Recommendation Report for Planning Permission

REF NO: A/175/18/PL

LOCATION: Rear of Caffyns Audi Worthing
Roundstone By-Pass
Angmering
BN16 4BD

PROPOSAL: Temporary car park extension.

Figure 15: Proposed site layout

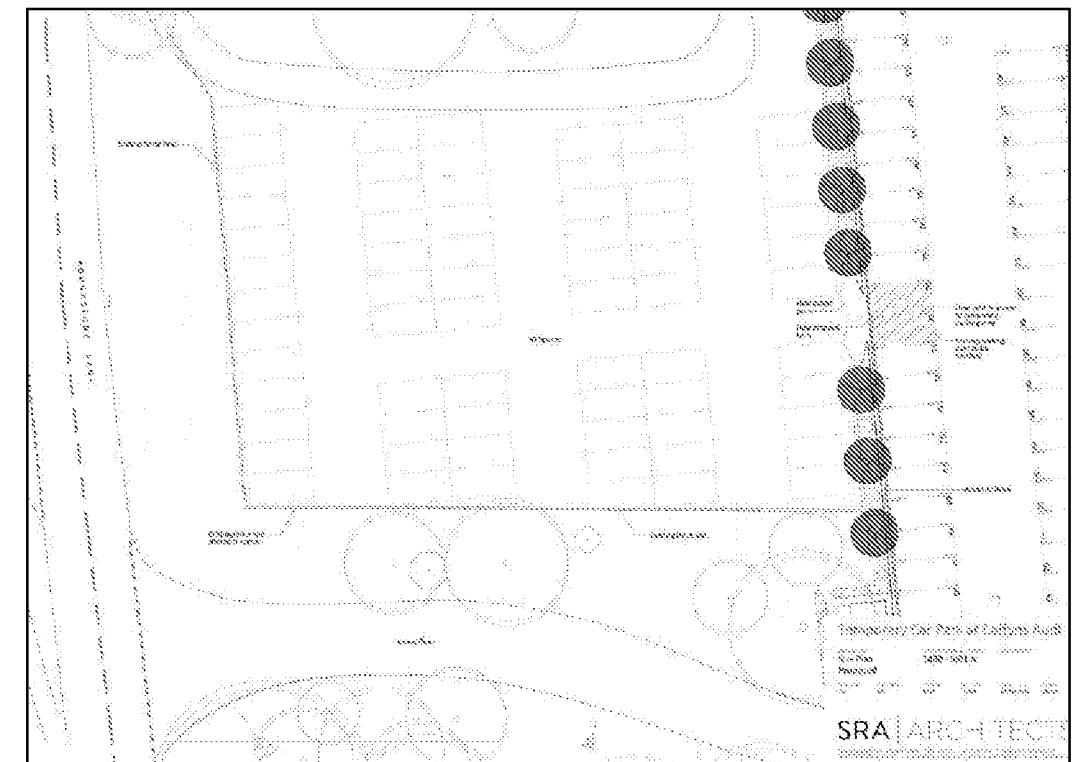
The proposals are to form a permeable car park area. However, 6F2 material is being specified, this class of material can include fines and therefore is not suitable. The construction of the car park could form a large impermeable area and result in increased flood risk elsewhere. The requested pre-commencement condition is therefore necessary. The agent has advised that the dualling work has been postponed and therefore the requested drainage conditions are now acceptable.

The drainage engineer has no objection provided pre commencement drainage conditions requiring winter ground water testing are imposed. The dualling works to the bypass have now been delayed and on this basis the agent has agreed to the requested pre commencement conditions.

Drawing Title
Roundstone Lane / Service Road Junction
Visibility and Swept Path Analysis

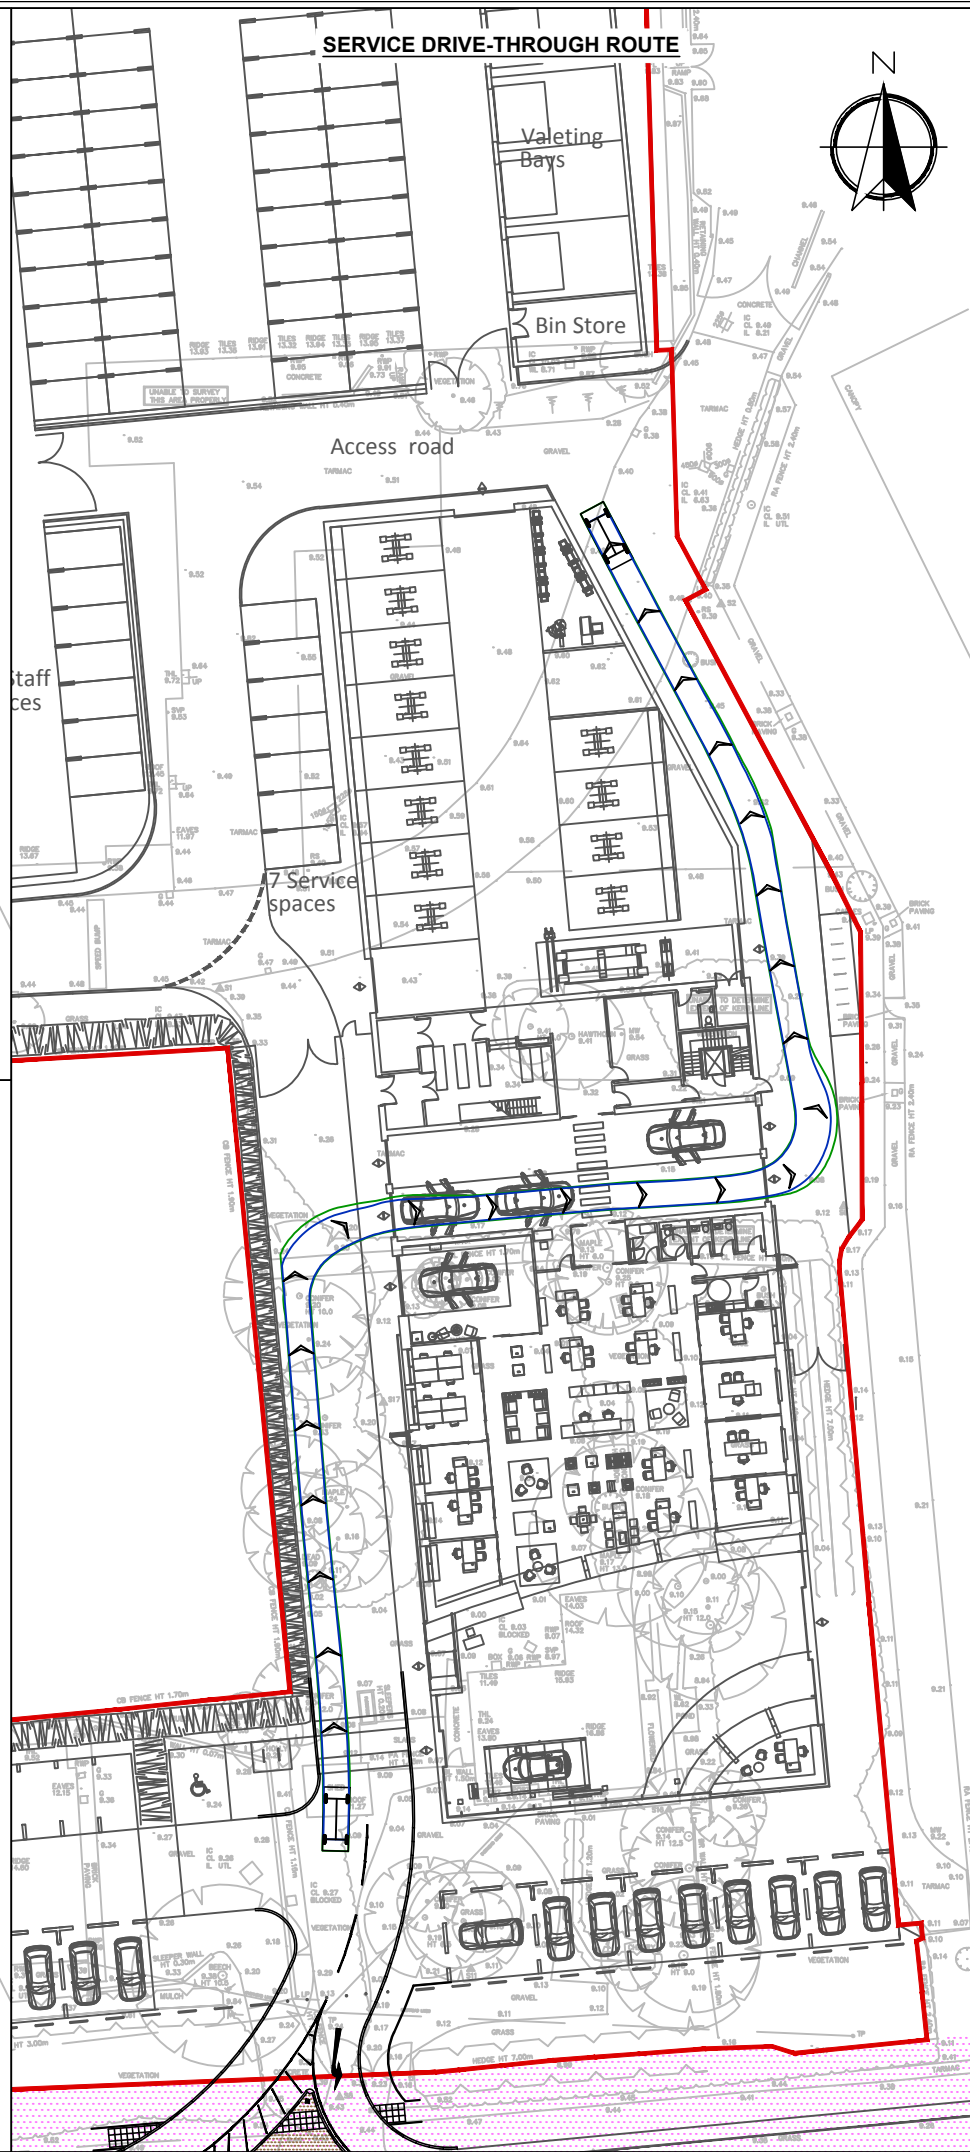
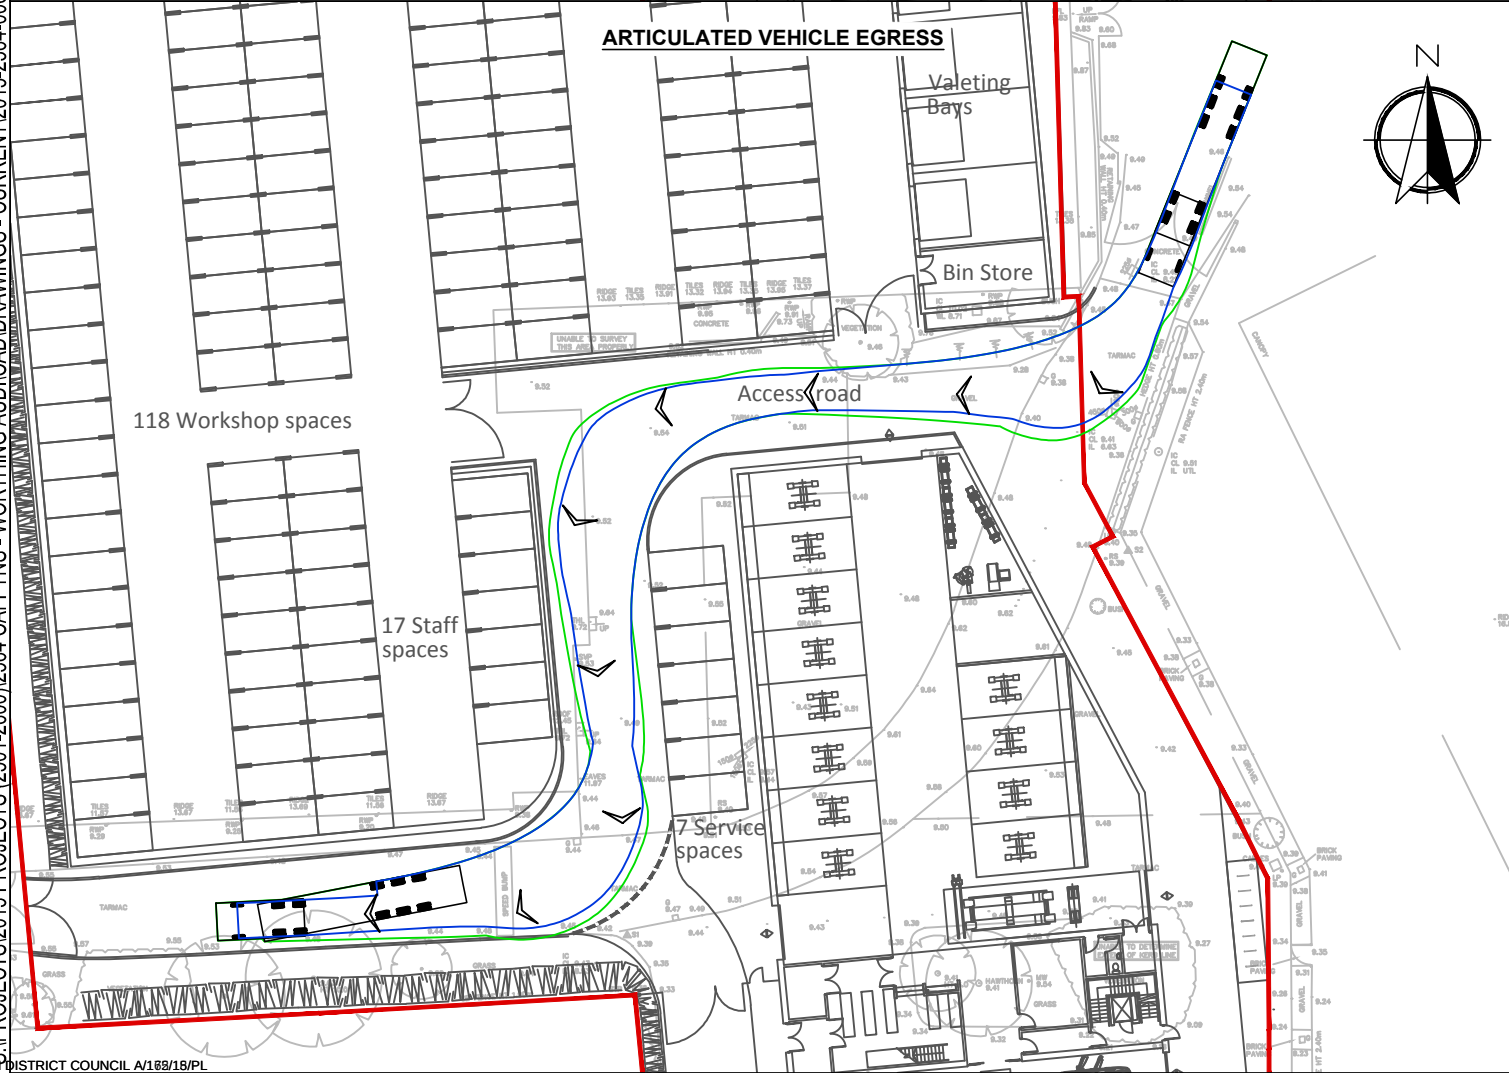
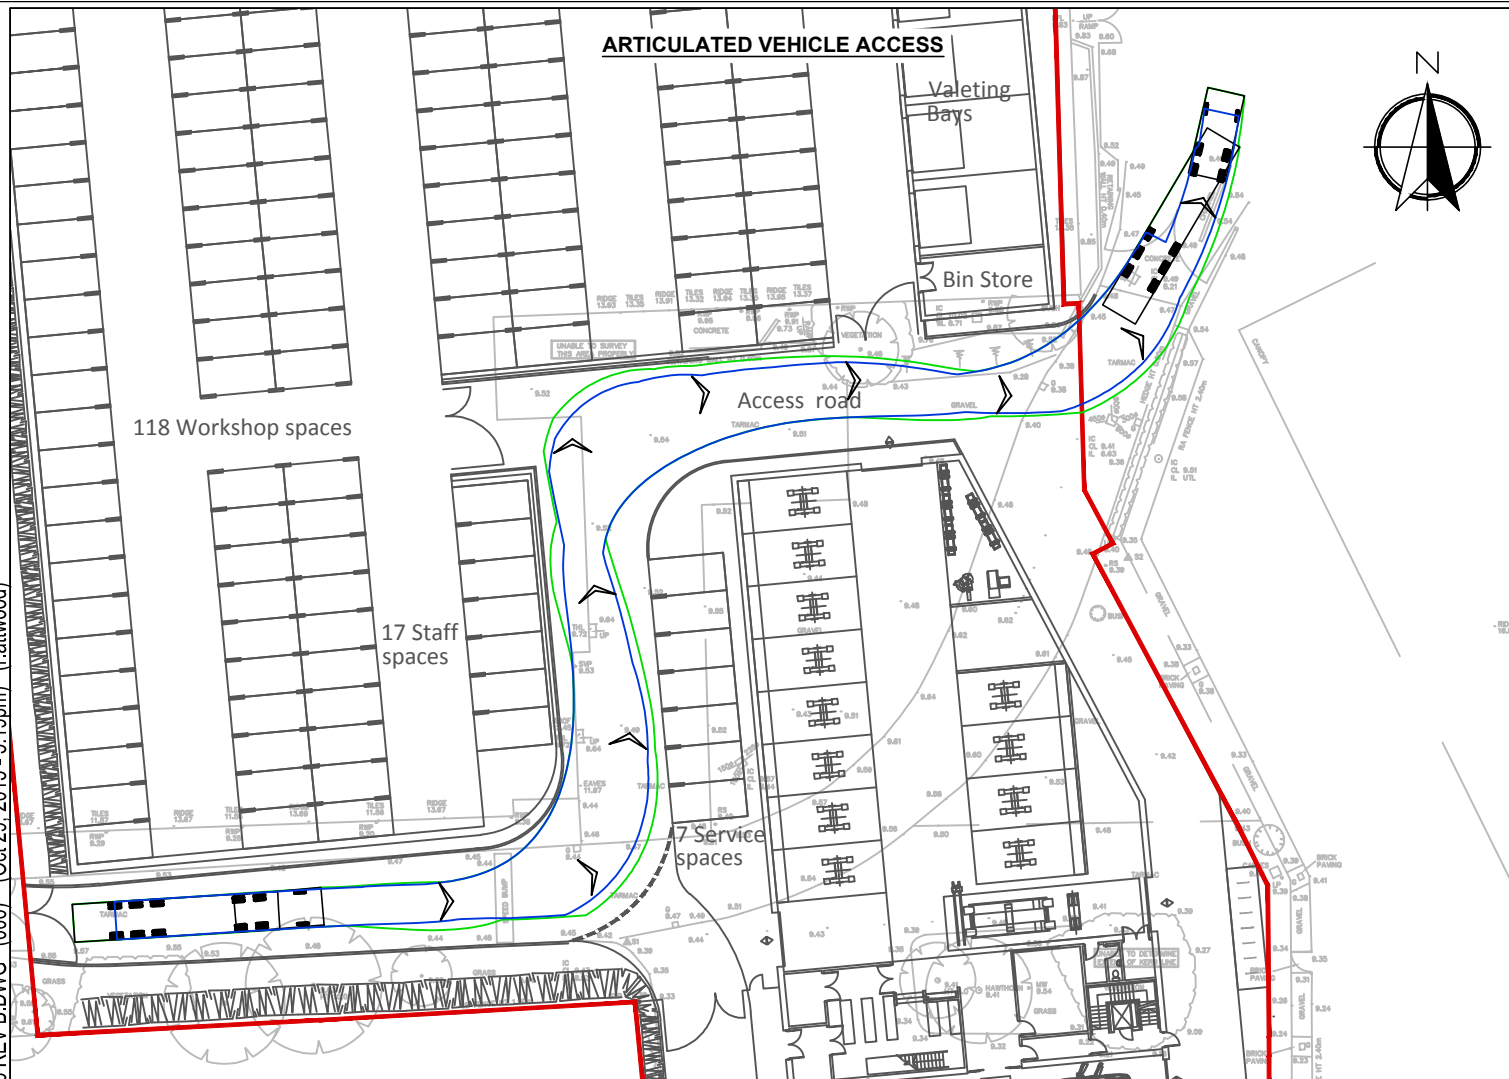
Tracking plots have been provided for the Roundstone Lane access. Access to the temporary car park can be gained from either the A259 or the Roundstone Lane access points. However there is a gate/fence between the building and the rear service area of the site presumably to stop customers driving through to the rear service area. The gate will need to be removed and clear signing installed within the site to inform customers of the parking to the rear (if accessing from the A259).

Making good of the verge is a private matter. County highways requested the submission of further details to demonstrate adequate space exists for manouvering of transporter vehicles and these have been provided. They now raise no objection.
